East Pye Solar
Statement of Common Ground:
Norfolk County Council

Revision 1
October 2026

Planning Inspectorate Reference: EN0110014
Document Reference: EN0110014/9.4
Rule 8(1)(e) Infrastructure Planning (Examination Procedure) Rules 2010

Drawing file: published-documents / EN0110014-000286-6.2.7.5.10 Environmental Statement Volume 2 Figure 7.5.10 Site 1 Zone of Theoretical Visibility (Revision 2).pdf

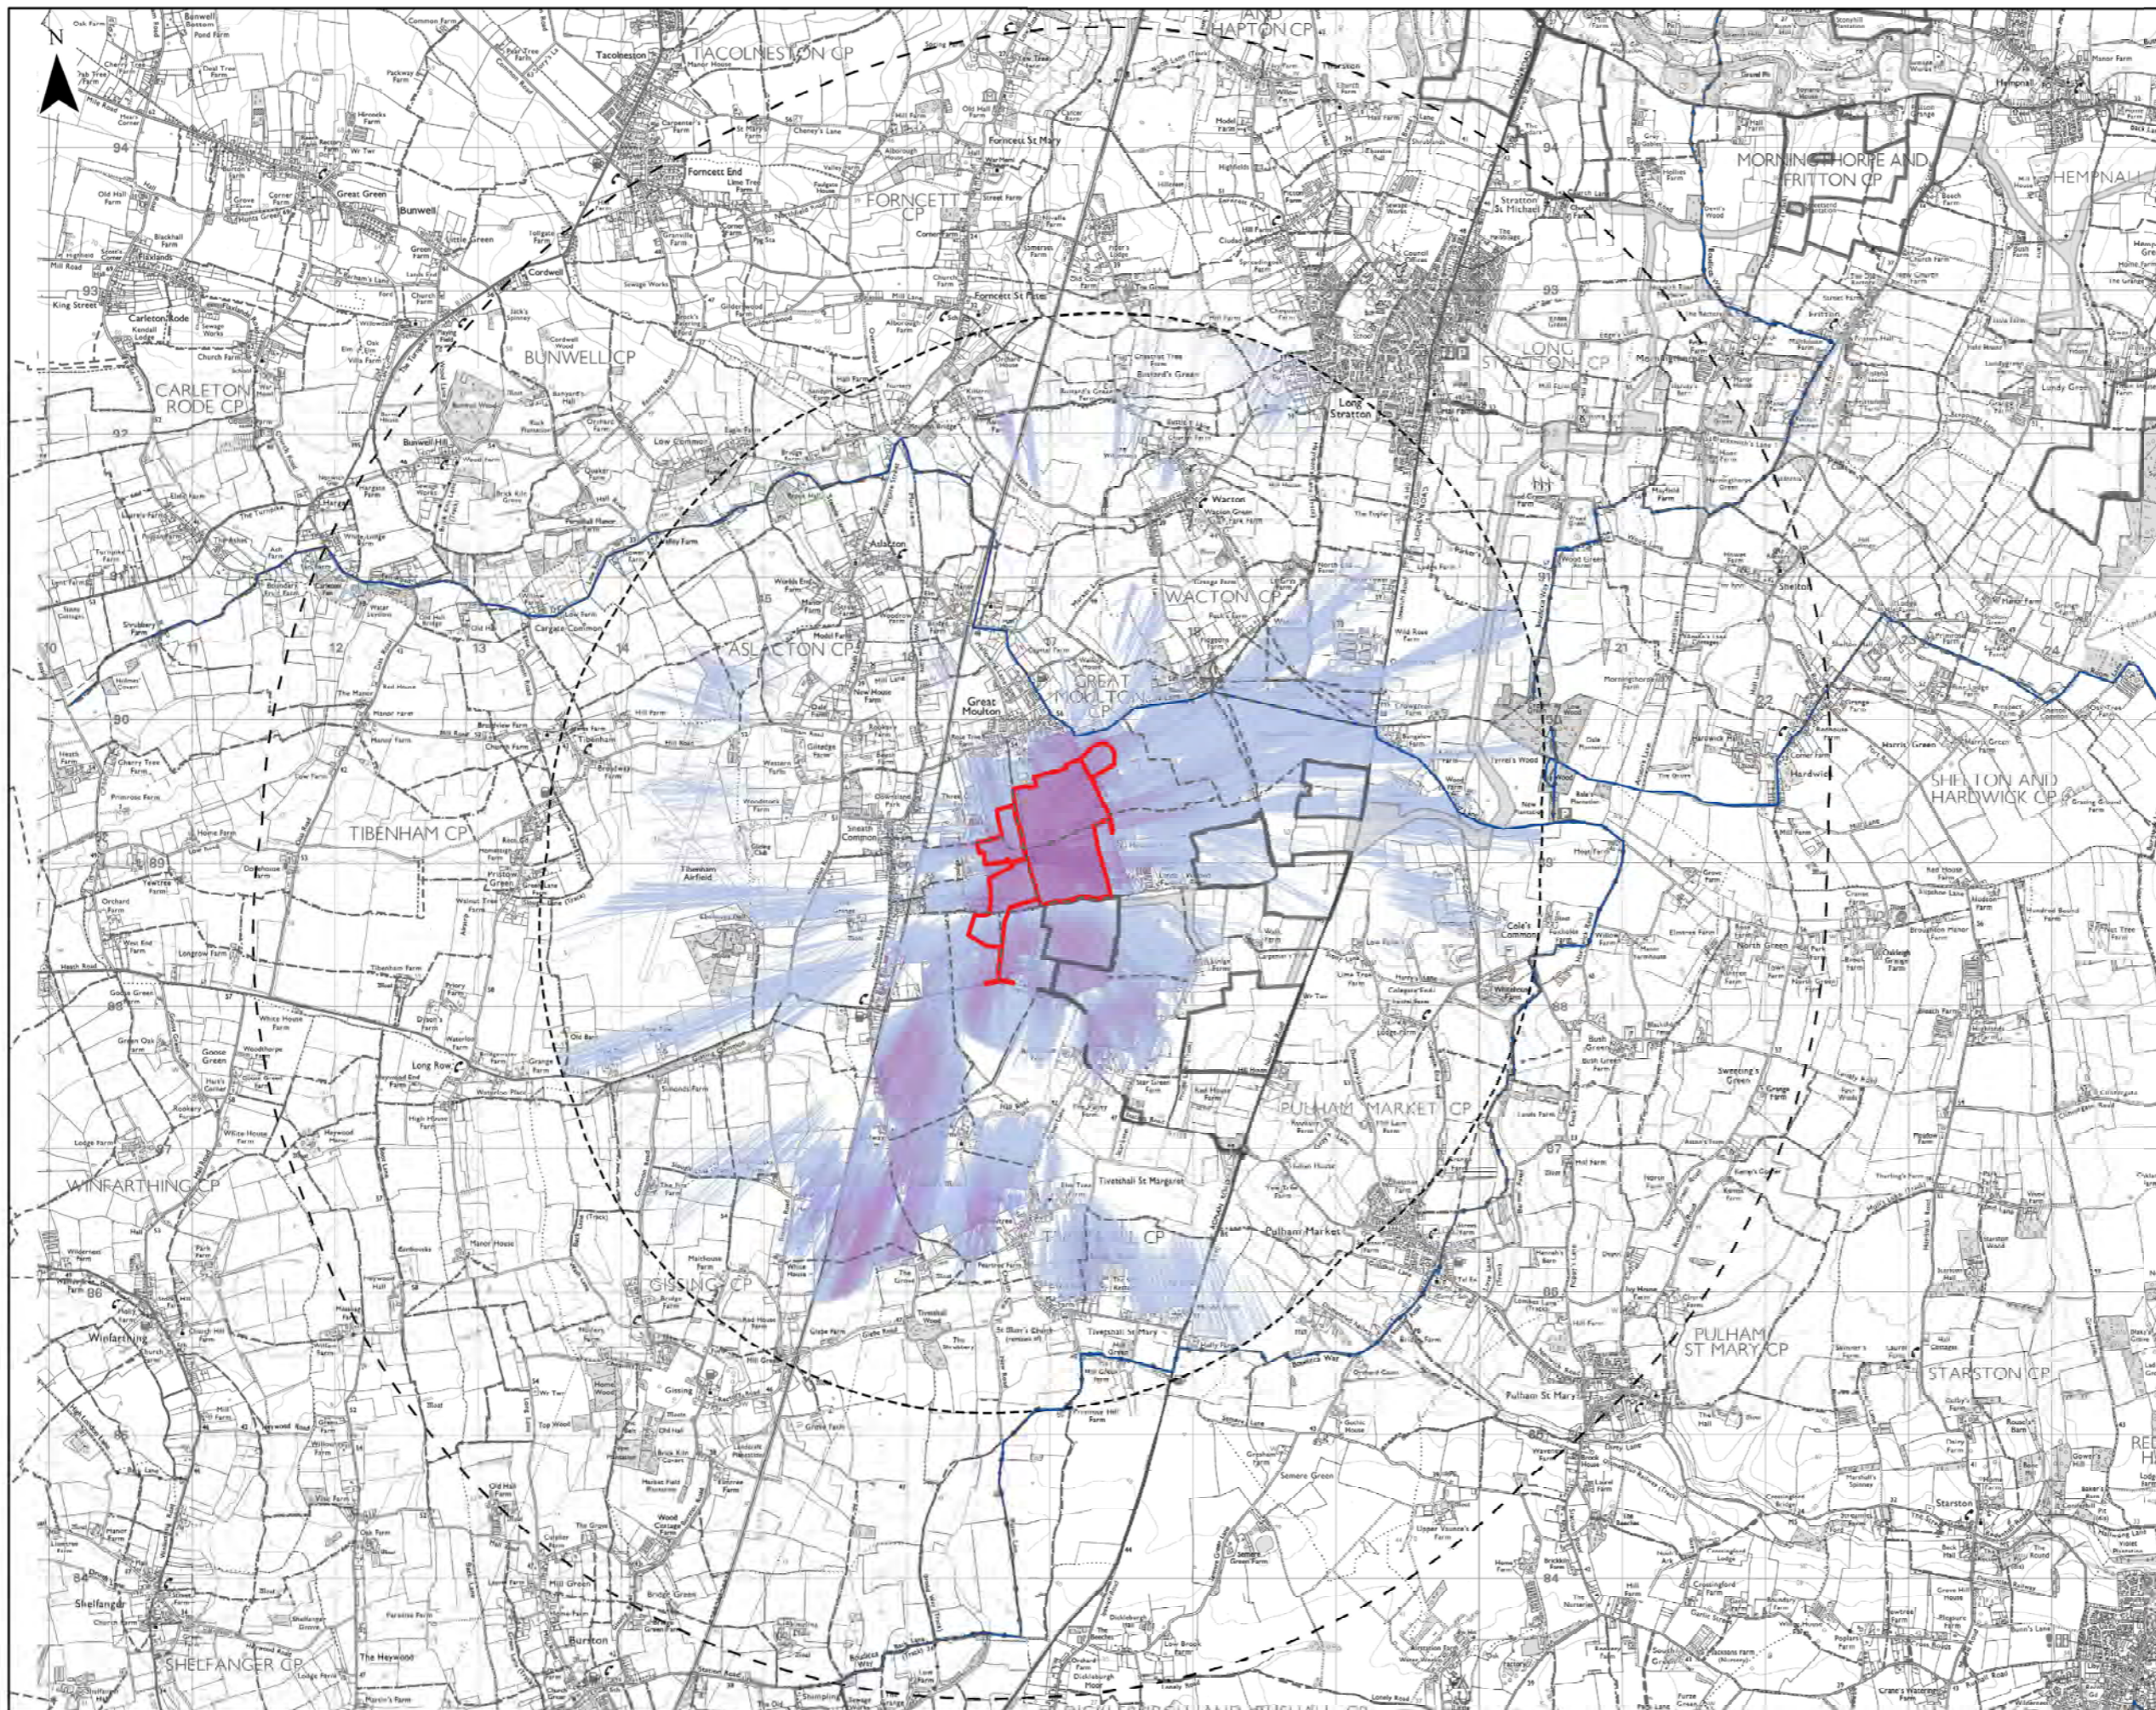
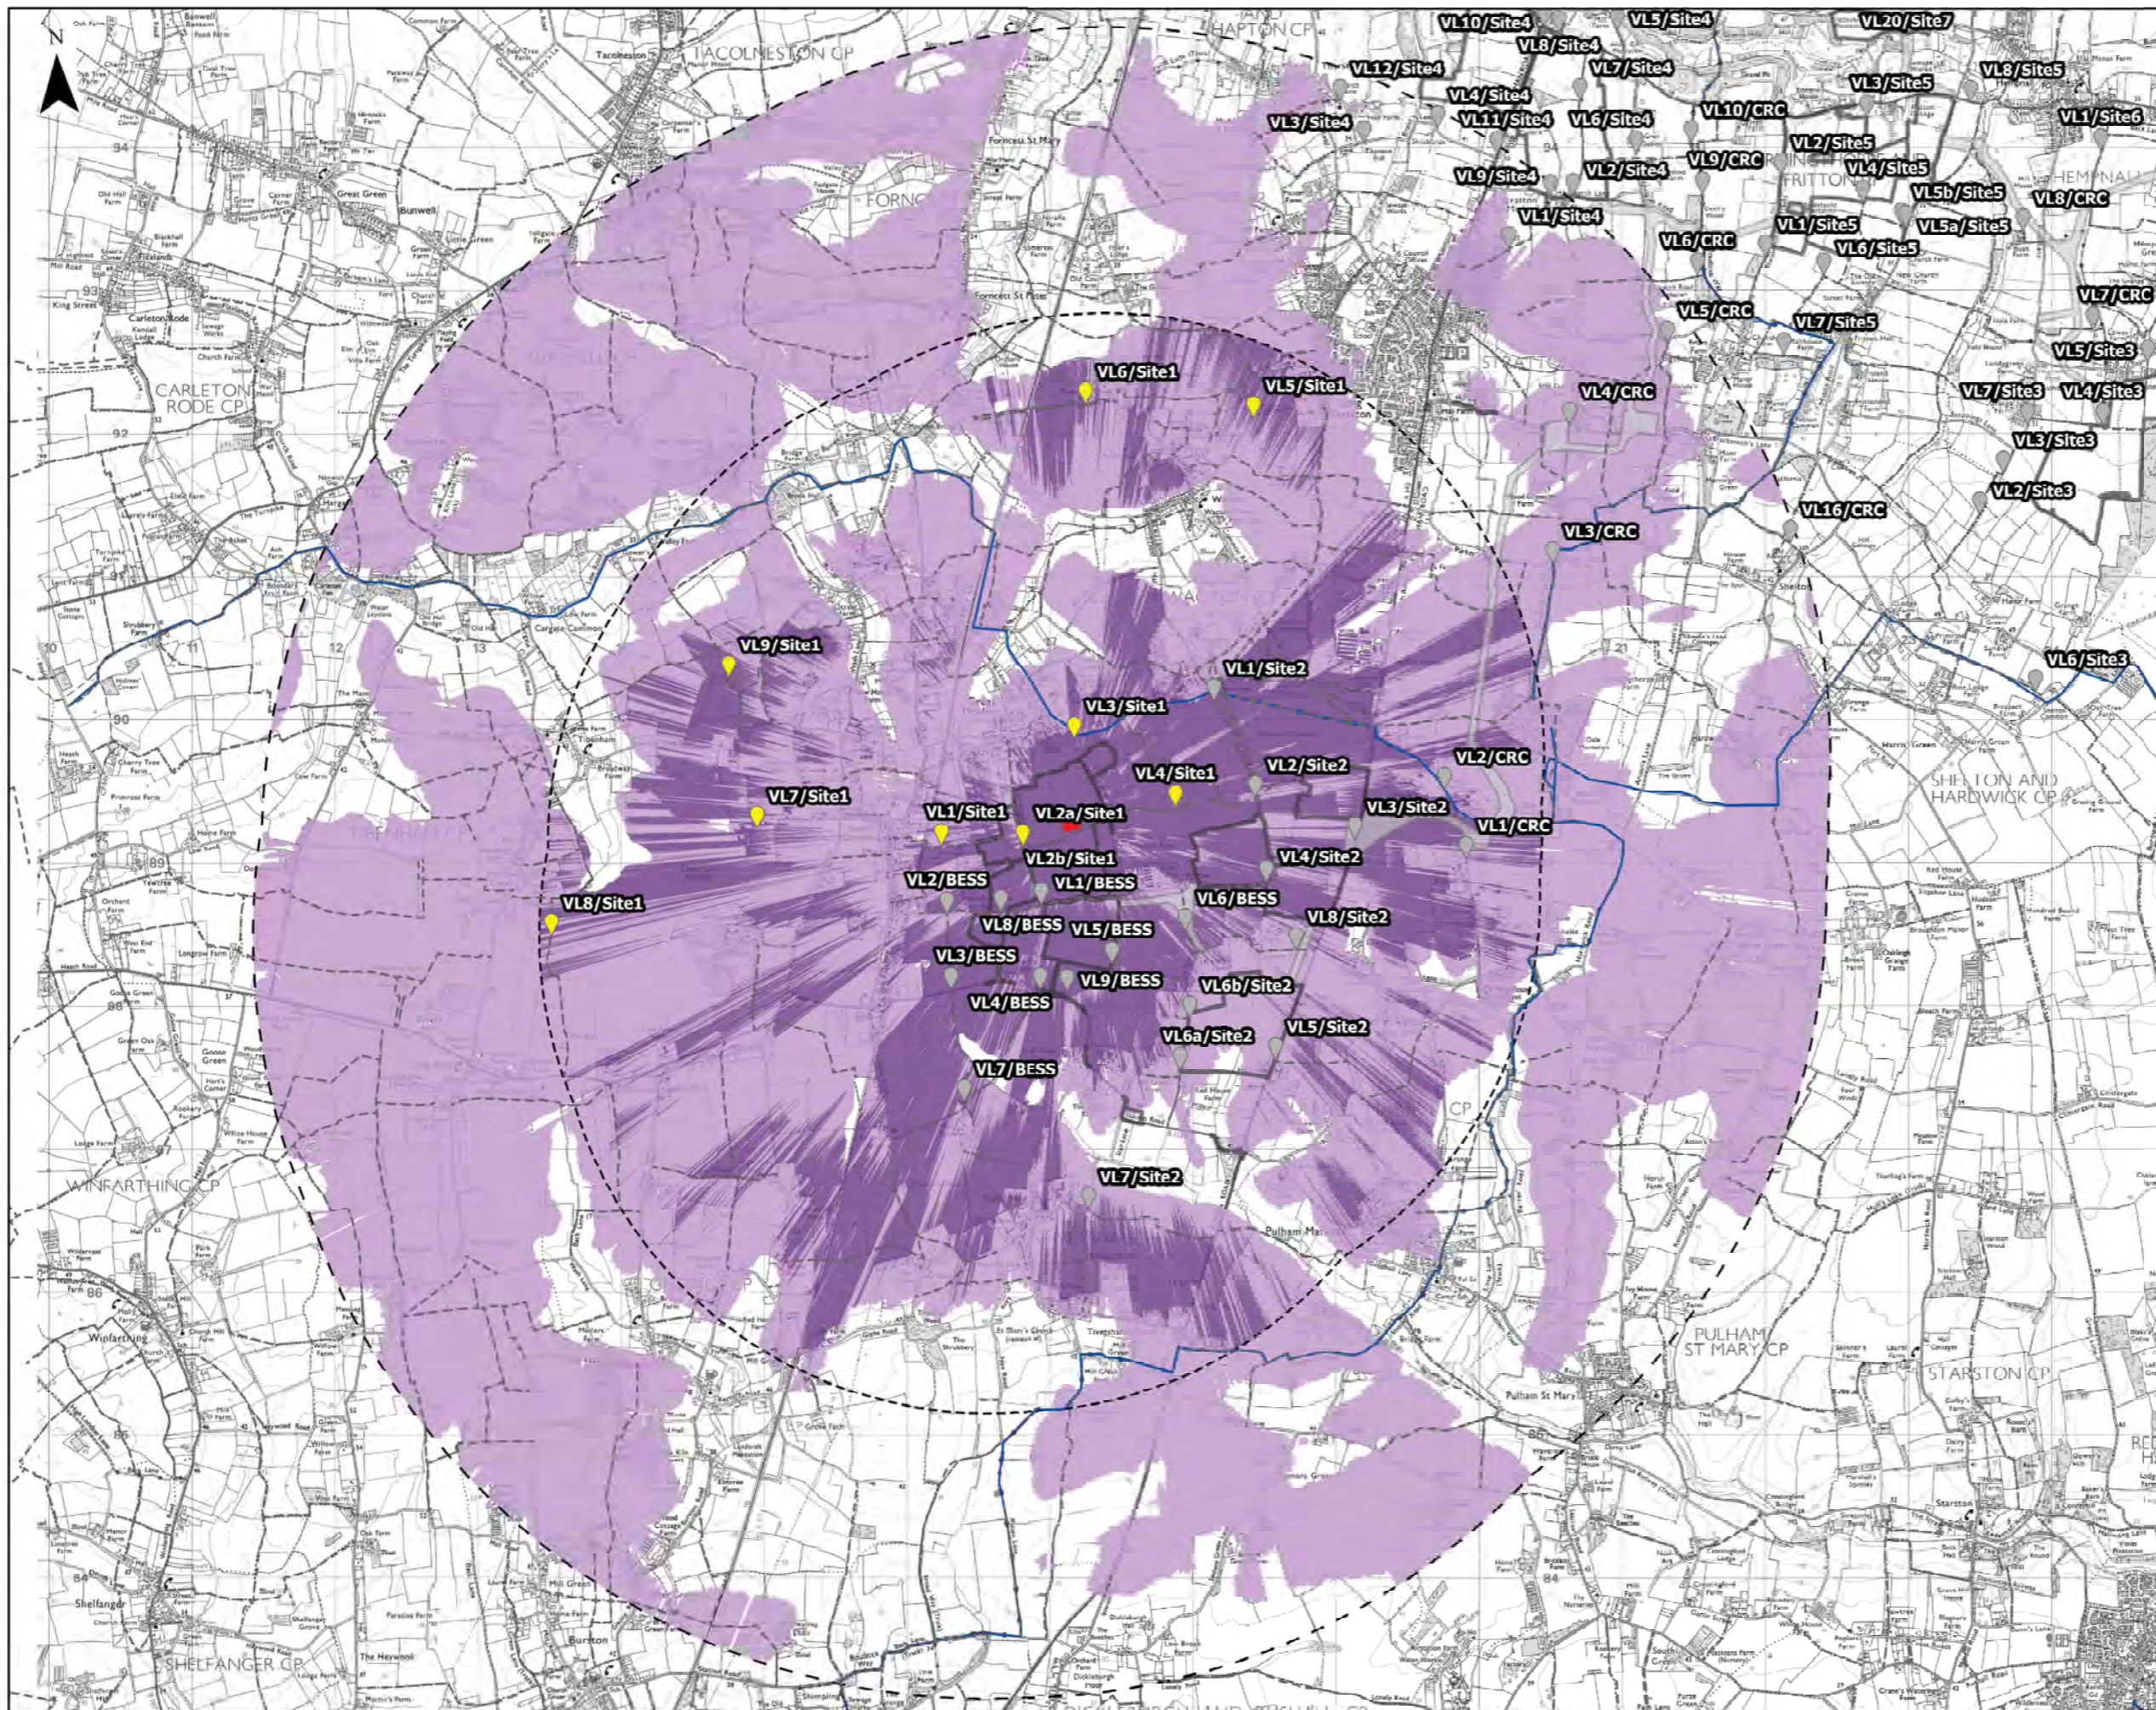
NCC LV – 5	Scope Landscape Character Assessments	ES Volume 1, Chapter 7 - Landscape and Visual [APP-043] ES Volume 3, Appendix 7.2 – Landscape Baseline [APP-119] ES Volume 2, Figure 7.2 - Landscape Character Plan [APP-067]	NCC has reviewed ES Chapter 7 [APP-043] alongside the supporting appendices. The LVIA follows industry standard guidance, including GLVIA3 (Guidelines for Landscape and Visual Impact Assessment) and relevant technical notes.	The published landscape character assessments that are relied upon at the national, regional, and local level and set out within ES Volume 1, Chapter 7 - Landscape and Visual [APP-043] and ES Volume 3, Appendix 7.2 - Landscape Baseline [APP-119] and ES Volume 2, Figure 7.2 - Landscape Character Plan [APP-067] are considered acceptable to inform the assessment baseline conditions.	Under Discussion
NCC LV – 6	Scheme design Concerns about new overhead lines/pylons as part of grid connection – suggest that grid connection cabling undergrounded and no new pylons.	ES Volume 1, Chapter 4 - The Scheme [APP-040] ES Volume 2, Figure 7.5.10 - Site 1 Zone of Theoretical Visibility [APP-079] ES Volume 2, Appendix 7.7 - Visual Assessment Tables [APP-147]	NCC is concerned the new overhead lines and pylons will have wider visual impact and will have disruption during construction. NCC suggested used of underground cables where possible to connect to the existing 400kV line.	The Applicant has sought to minimise the effect and extent for new overhead cables with siting of the National Grid Substation in close proximity to the existing 400kV line. Grid connection infrastructure will nevertheless be required between the National Grid Substation and the existing 400 kV overhead line (Norwich Main – Bramford). The final design of the substation is ultimately at National Grid's discretion. As such, the Applicant has assessed a reasonable worse case scenario in which the connection from the National Grid substation and the NETS was assessed as using overhead lines, as opposed to underground cables. The Scheme proposes to divert the existing 400 kV overhead line into a newly constructed National Grid Substation. ES Volume 1, Chapter 4 - The Scheme [APP-040] describes the proposed works in relation to the grid connection and proposed pylons.	Under Discussion

Reference	Matter Topic	Document Reference of Matters	Consultee Position	Applicant's Position	Status
				A comparative ZTV is produced as part of ES Volume 2, Figure 7.5.10 - Site 1 Zone of Theoretical Visibility [AS-007] . The Applicant considers the visibility of the additional pylon is similar to the baseline. Where the proposed additional pylon has the potential to influence visual amenity, this has been assessed within ES Volume 2, Appendix 7.7 - Visual Assessment Tables [APP-147] .	
NCC LV – 7	Scheme design Favoured national grid Substation option further away from Great Moulton	Site Selection Assessment [APP-215]	The consultee favoured the option with the National Grid Substation further away from Great Moulton.	The Site Selection Assessment [APP-215] explains the rationale for why the National Grid Substation has been located at Site 1b.	Not Agreed
NCC LV – 8	Scheme design Concern about the upgrade of the 132 kV substation south of Great Moulton to 400kV which will have a greater visual impact.	ES Volume 1, Chapter 7 - Landscape and Visual [APP-043]	The consultee is concerned about the upgrade of the 132 kV substation south of Great Moulton to 400kV which will have a greater visual impact.	The visual effects of the 400kV Project Sub-Station adjacent to the proposed National Grid substation south of Great Moulton has been assessed within ES Volume 1, Chapter 7 - Landscape and Visual [APP-043]. As set out in the Site Selection Assessment [APP-215], the chosen location for the National Grid Substation avoids major designated areas of ecological or cultural importance, with only limited priority habitats and no heritage assets, County Wildlife Sites or Ancient Woodland present. The National Grid Substation and overhead lines would therefore avoid areas of high amenity, cultural, and scientific value in line with the Holford / Horlock Rules and NPS EN-5. As part of the design evolution, the National Grid Substation was also reorientated north south to enable greater opportunities of screening from existing vegetation to the north to reduce the visibility from Great Moulton and provide a greater offset from Narrowgate Way PRow demonstrating that landscape and visual effects have been minimised through iterative design. NPS EN-1 states at para 5.10.5 that ‘<i>Virtually all nationally significant energy infrastructure projects will have adverse effects on the landscape</i>’, and at para 5.10.13 that ‘<i>All proposed energy infrastructure is likely to have visual effects for many receptors around proposed sites</i>’. Due to the scale of the proposed infrastructure in Site 1, the Applicant identifies change to some of the key characteristics and visual amenity of Site 1	Under Discussion
